CITY OF ALBUQUERQUE

June 23, 2009

RE: Villa Loma Estates, (F-22/D025)
Engineers Certification for Release of Financial Guaranty
Engineers Stamp dated 09/18/2007
Engineers Certification dated 06/17/2009 & 6-23-09

RE: Villa Loma Estates, (F-22/D025)
Pad Certification-Not Approved
Engineers Stamp dated 9/18/2007
Engineers Certification dated 06/17/2009
City Project #: 746882

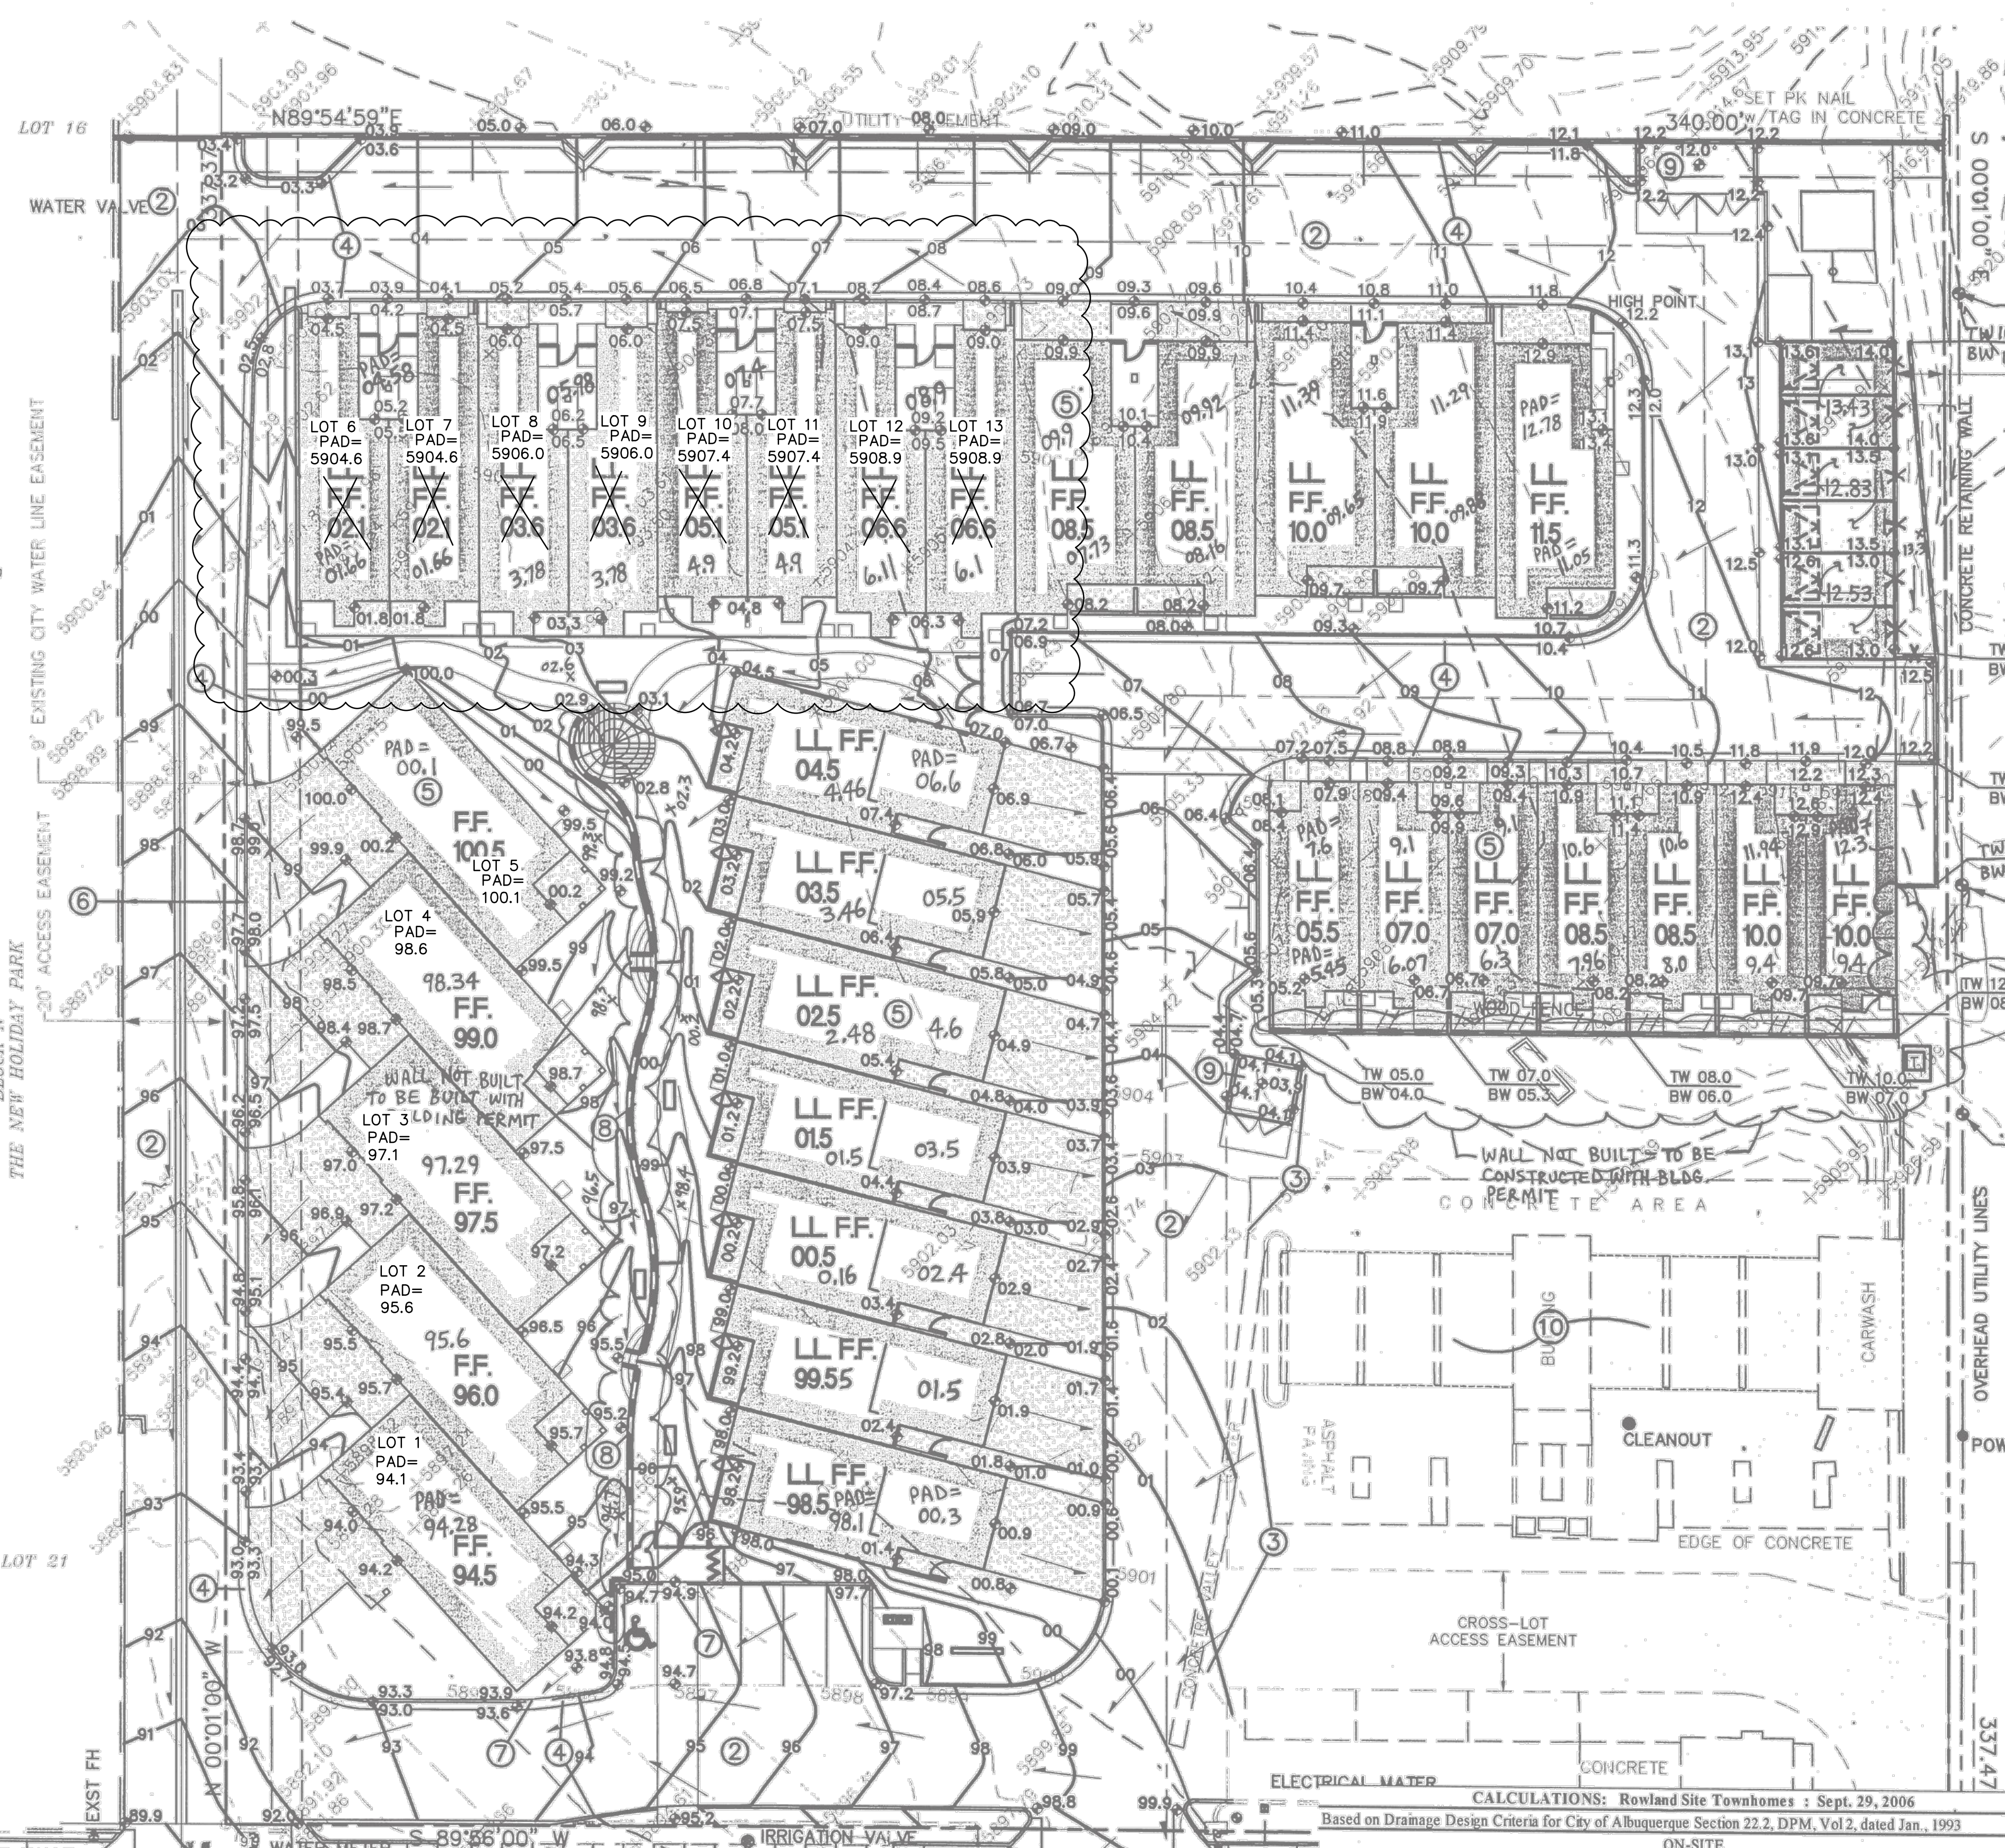
Based upon the information provided in your Engineer's Pad-Certification dated 06/17/2009, the above referenced plan cannot be approved for Pad Certification until the following comments are addressed:

1. Provide additional spot elevation for the north/south swale between the buildings.
2. All retaining walls will need to be completed on the east side of the site.
